Our reference: P-344120-M1H0
Contact: Kathryn Saunders
Telephone: (02) 4732 8567

Amended Report for Oakdale West Estate Precinct - Mod 10 (SSD-7348-Mod-10)

Figure 1 - Sign 1- approved

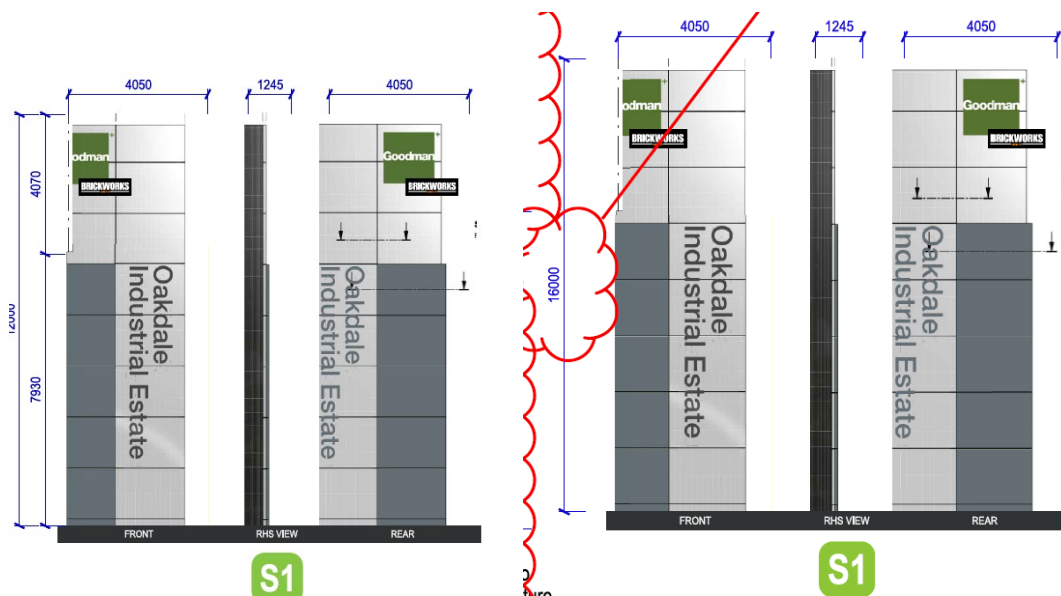
The proposed 16m high pylon sign is excessive in height, and it is recommended that the applicant be advised to reduce its height significantly, to better align with Section C9 Advertising and Signage and Chapter E6 Erskine Business Park of Council's DCP and Chapter 3, Schedule 5 of State Environmental Planning Policy (Industry and Employment) 2021.
